**Our Case Number:** ABP-313182-22

**Re:** BusConnects Clongriffin to City Centre Core Bus Corridor Scheme  
County Dublin

ABP case ref: 313182

## **BUSCONNECTS CORE BUS CORRIDORS CLONGRIFFIN SCHEME**

CLONGRIFFIN TO CITY CENTRE CORE BUS CORRIDOR SCHEME  
JUNCTION SYSTEMS DESIGN  
CLAREHALL

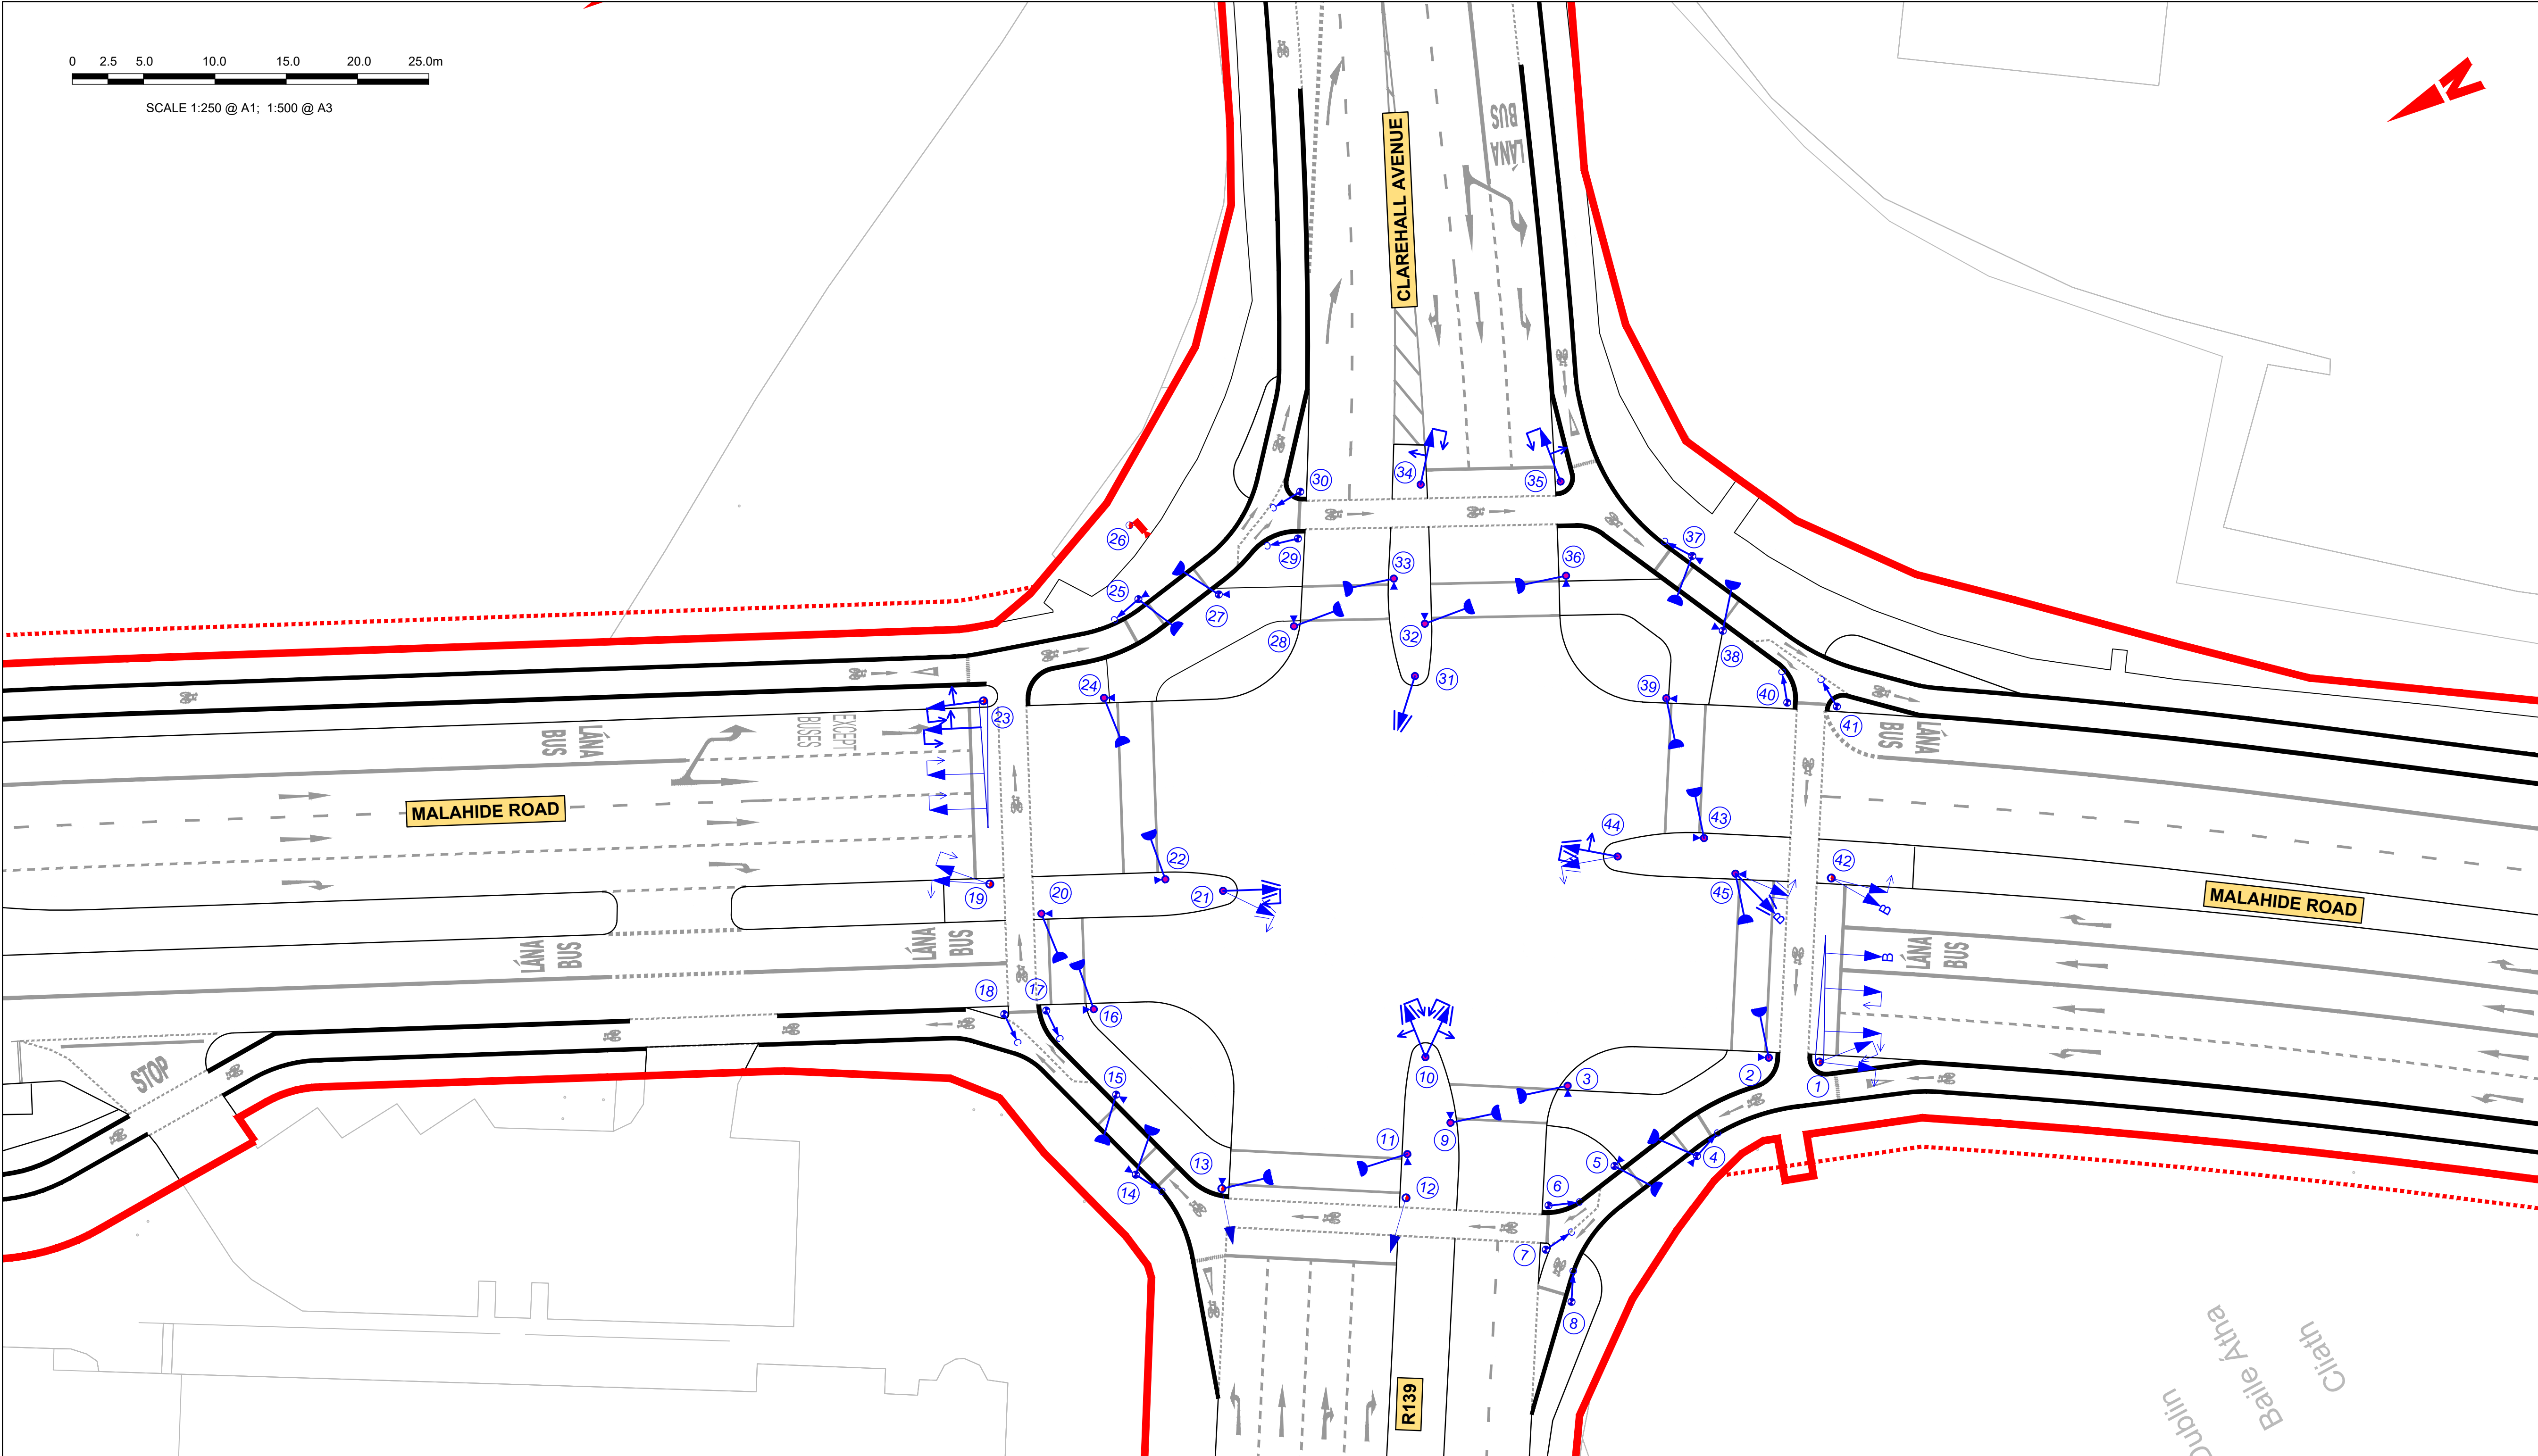
This is most evident at the Malahide Road junction with Clarehall Shopping Centre where a simple T-junction serving as an entrance to both a commercial and residential area is widened to eight lanes. Such large roads will discourage active travel and result in undesirable levels of driving and is at odds with the aims of the project. Furthermore, the NTA proposes acquiring land to build this excessively wide road when a more suitable and less car-dominant design could be built within the existing boundary.

Furthermore, some junctions are missing necessary pedestrian crossings at one or more arm such as at the Malahide Road/Clarehall Shopping Centre junction and the Malahide Road/Griffith Avenue junction.

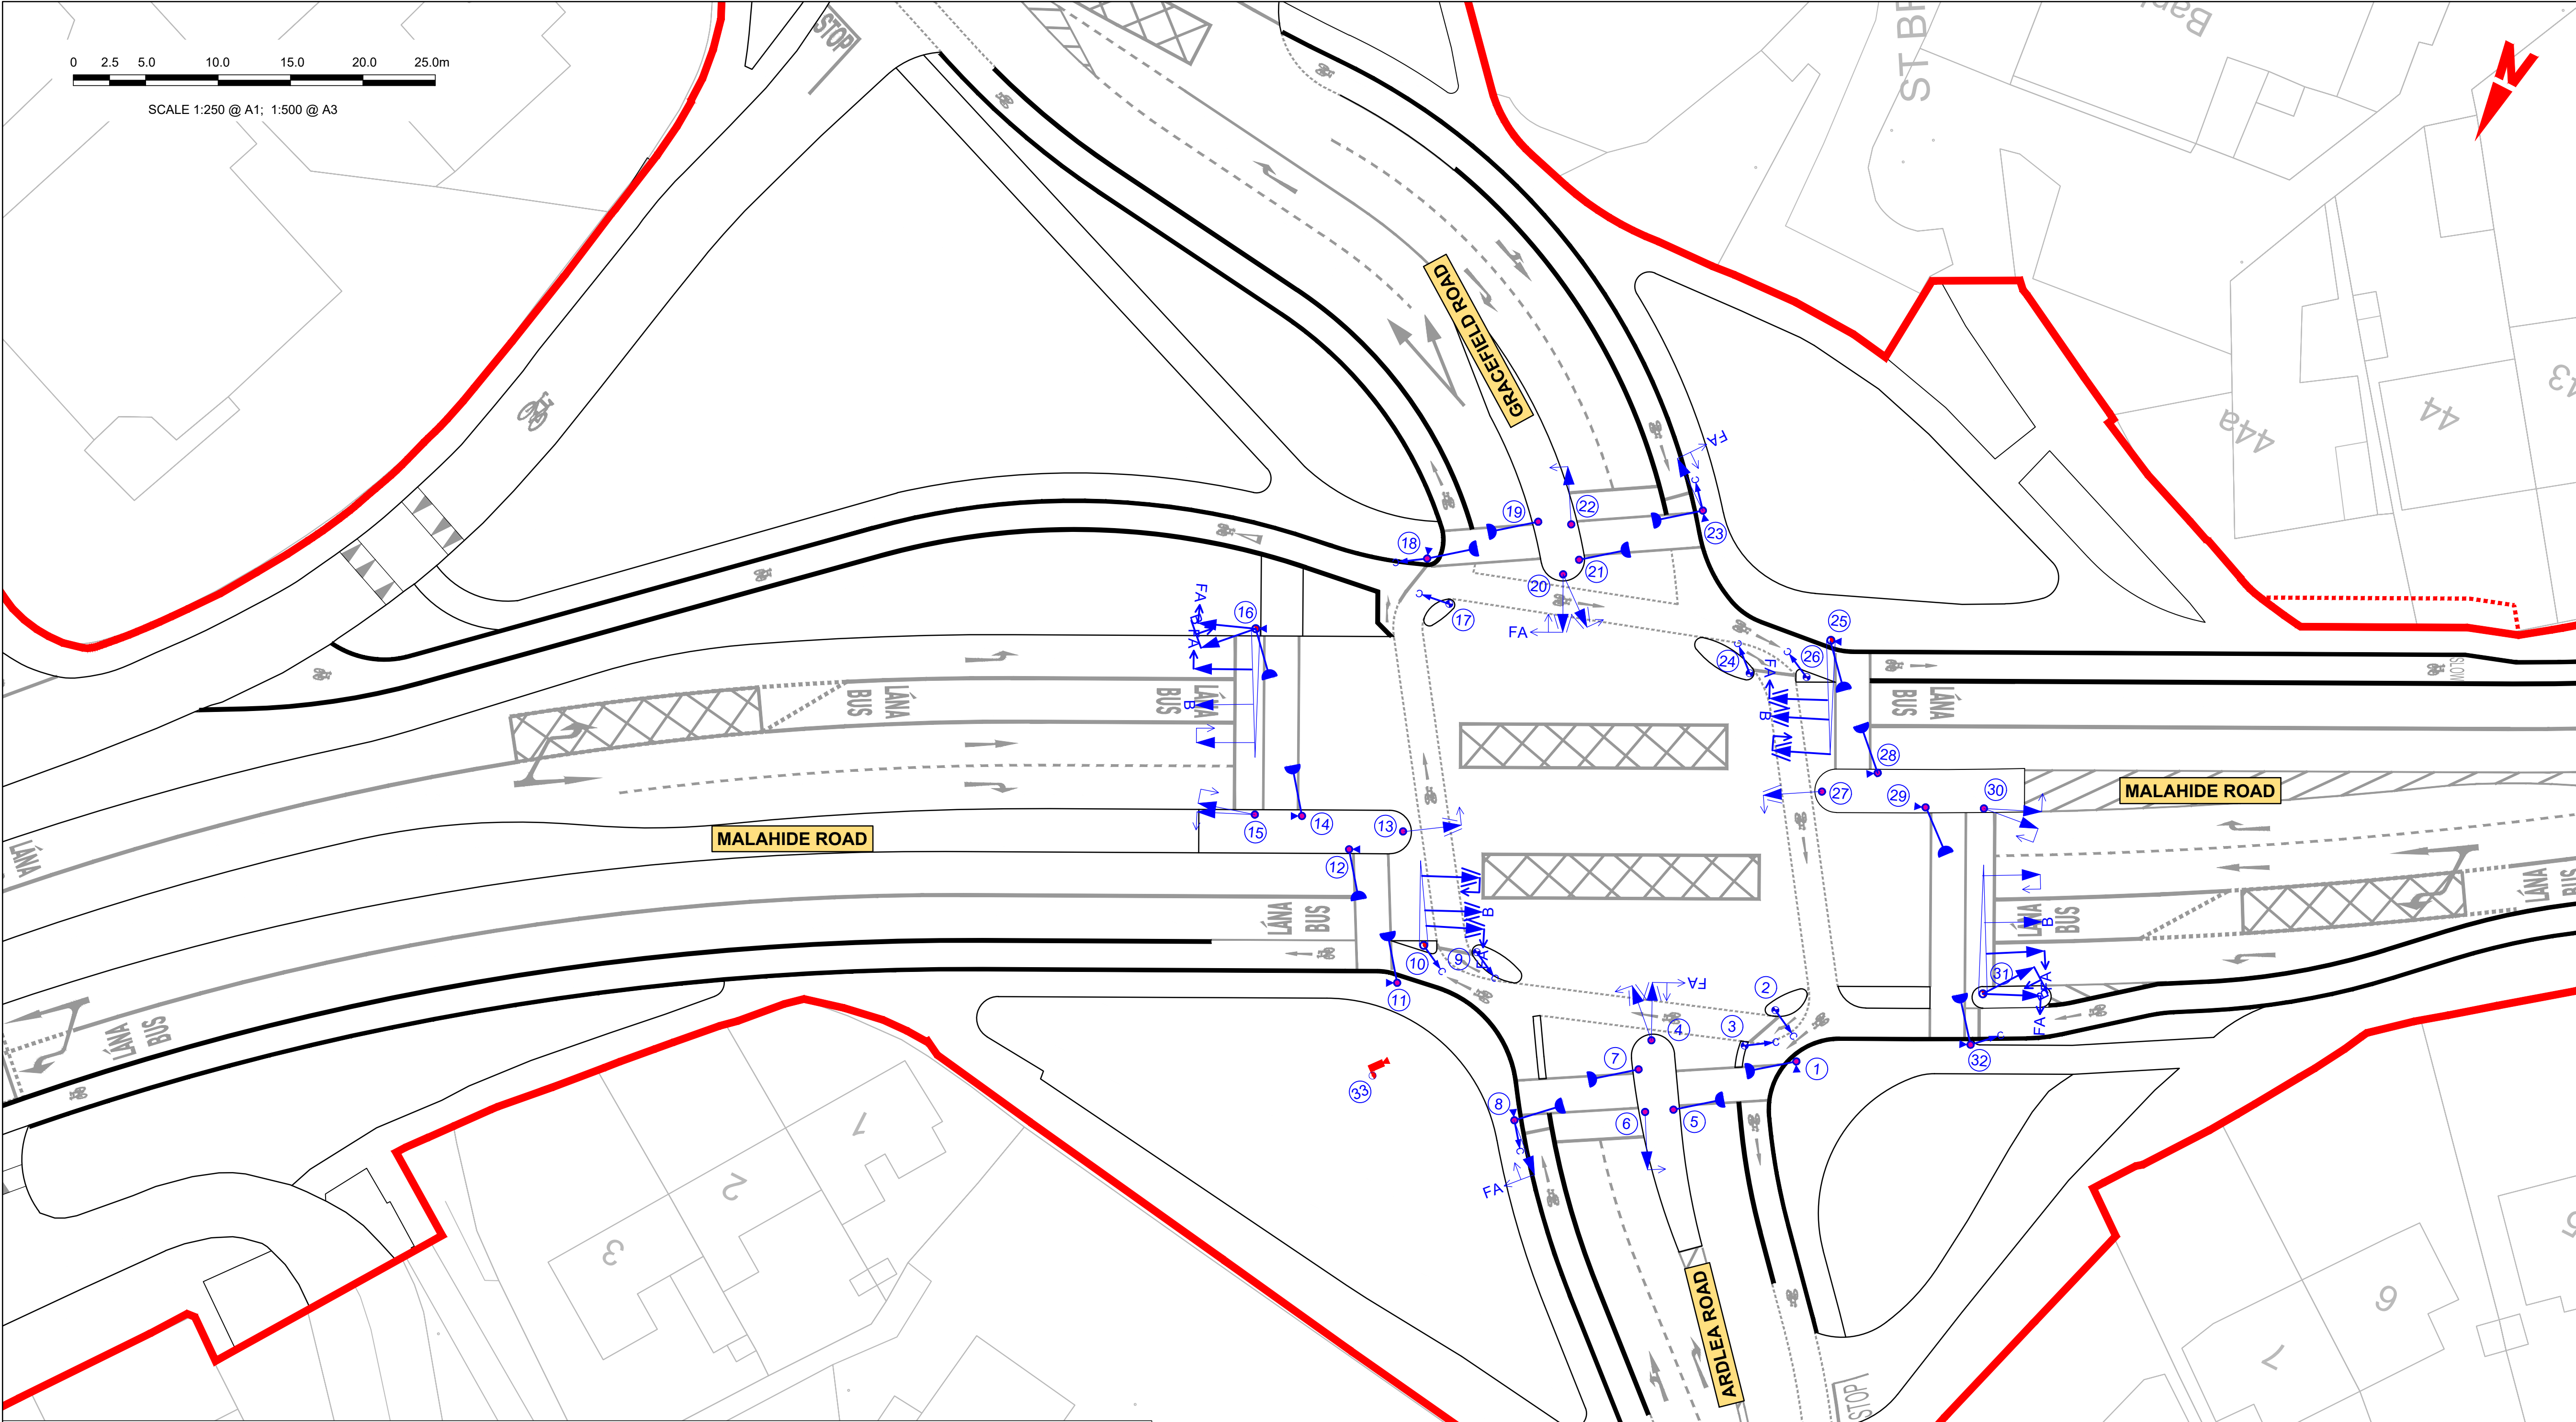
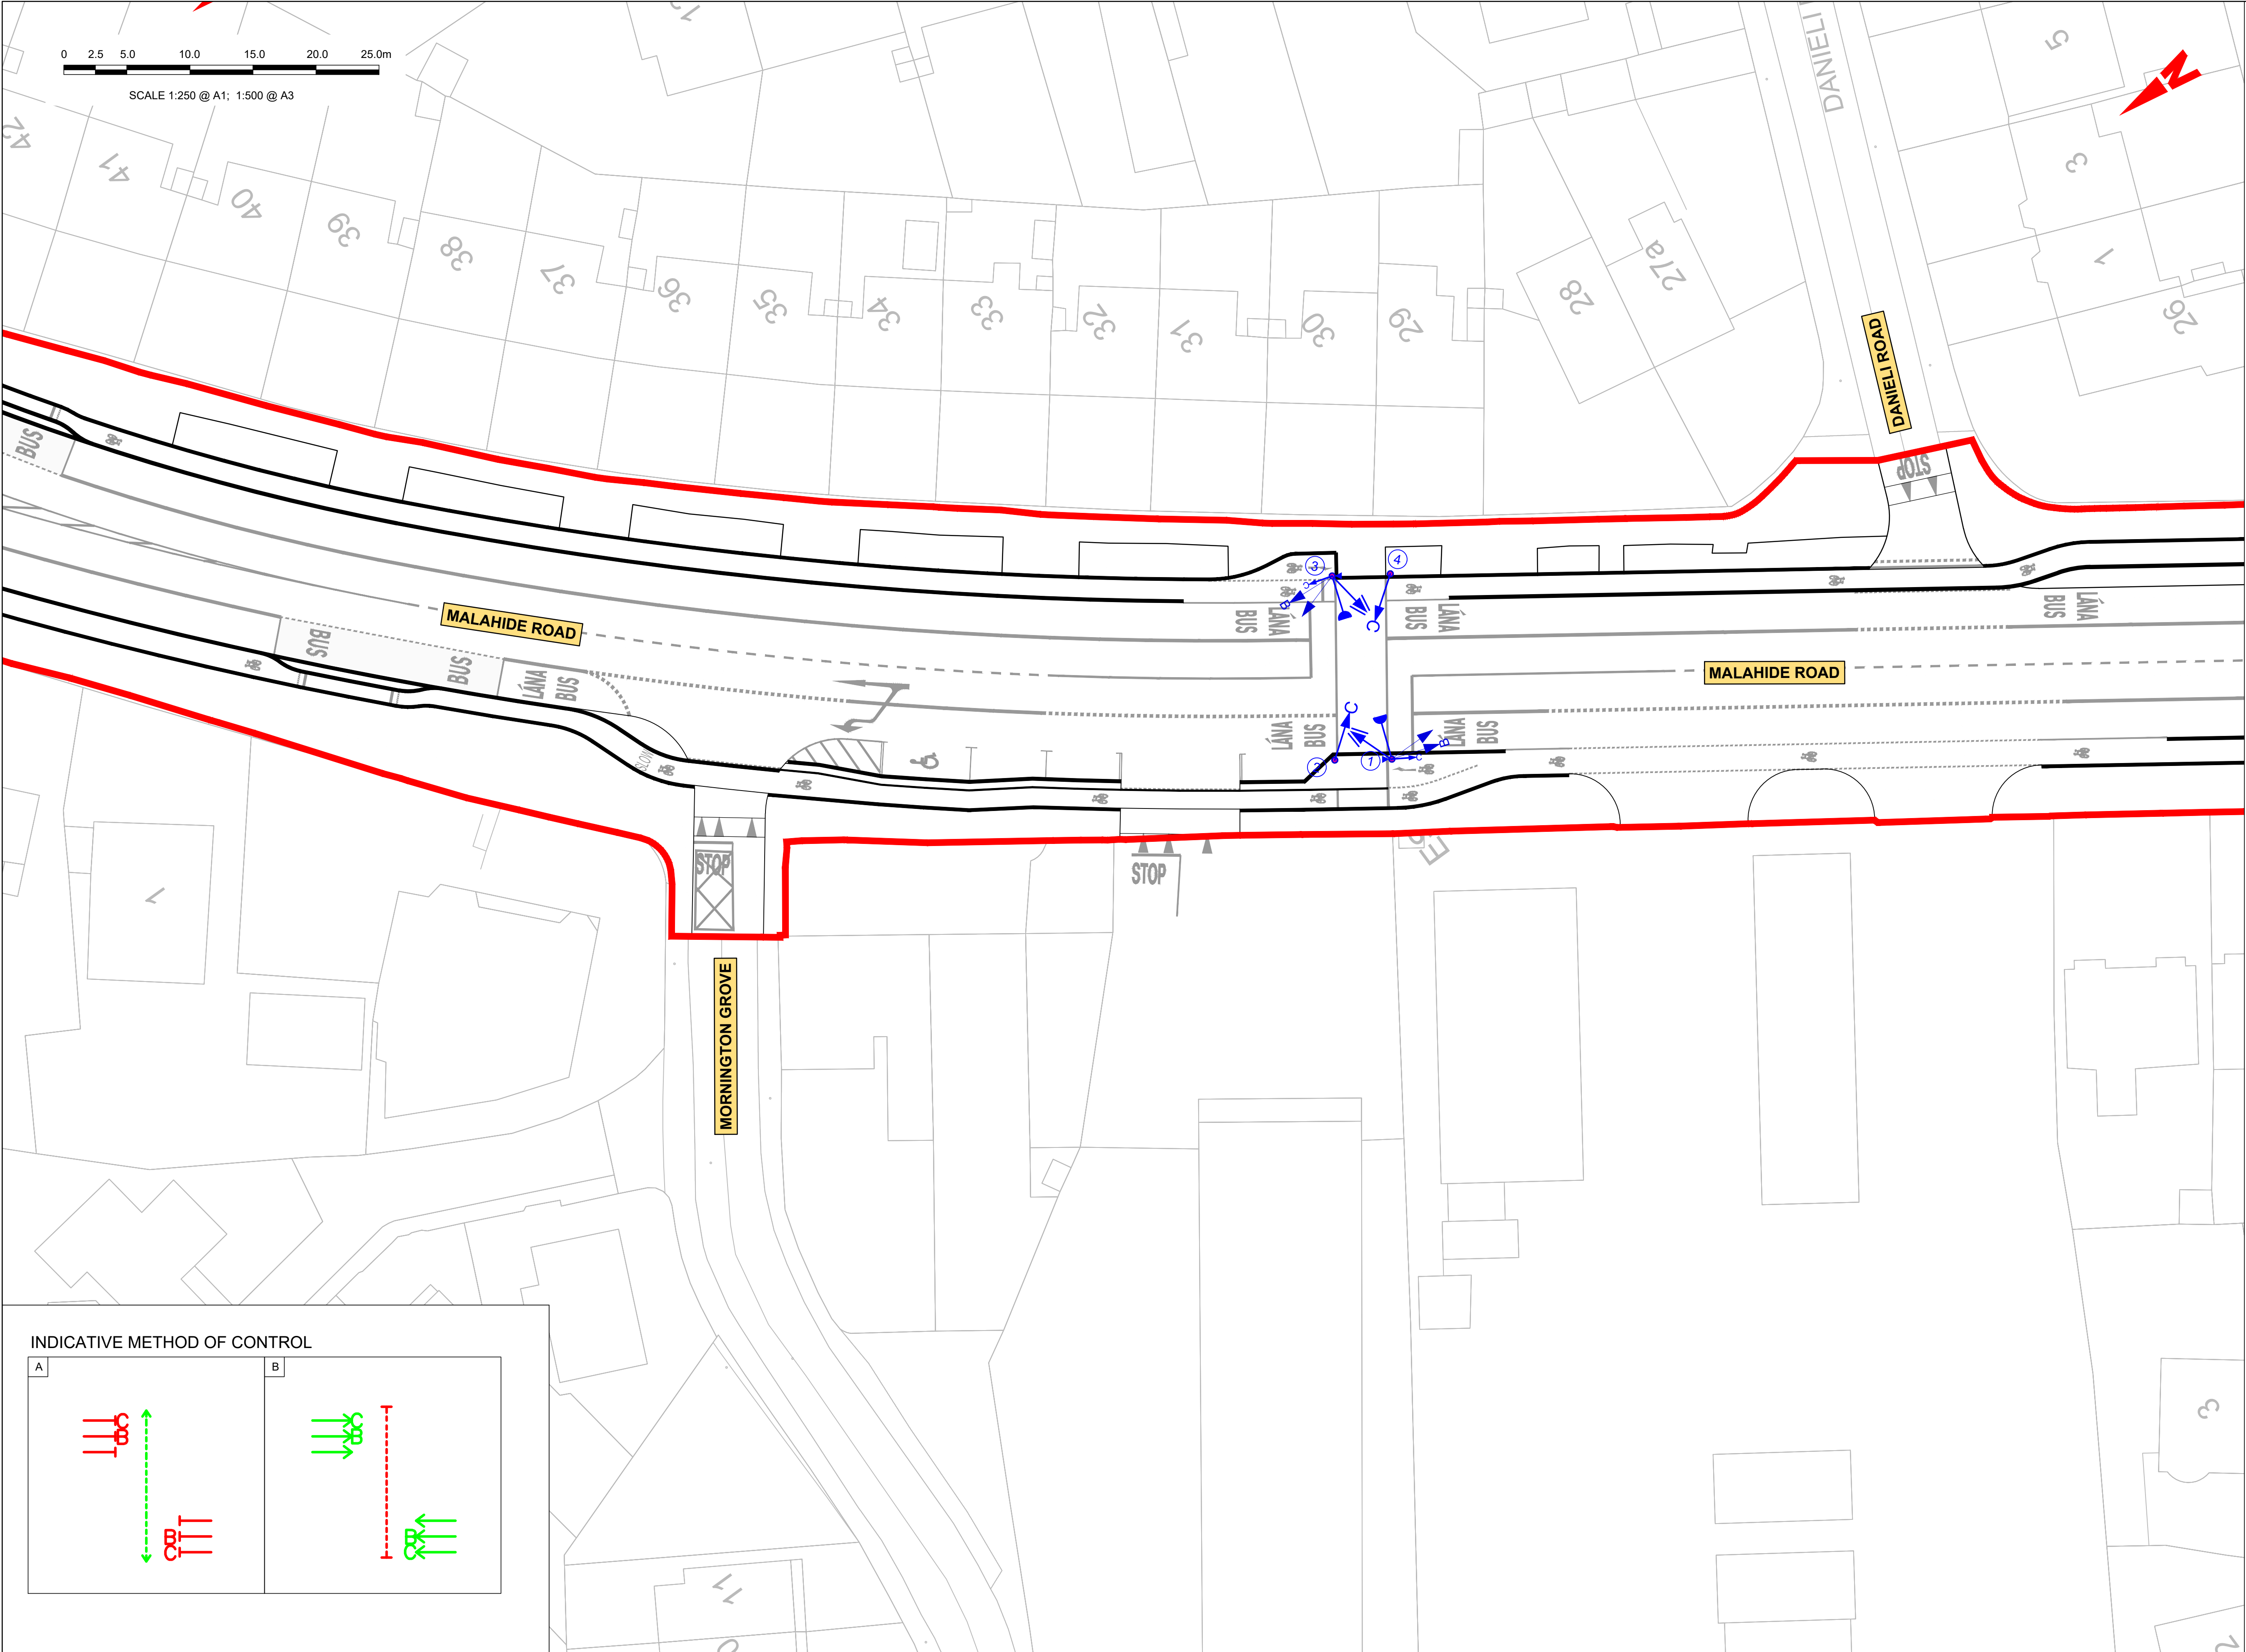
Figure 1 NTA's 'Dublin-style' junction at Tonleeg Road

When compared to the proven Dutch junction, the NTA's design poses a great risk of left-turning drivers crashing into cyclists and has larger crossing distances for

pedestrians. The few existing examples of this NTA design in Dublin has been widely regarded as unsafe. We request that the NTA use Dutch-style junctions (Figure 2) or CYCLOPS junctions (Figure 3) throughout the project.
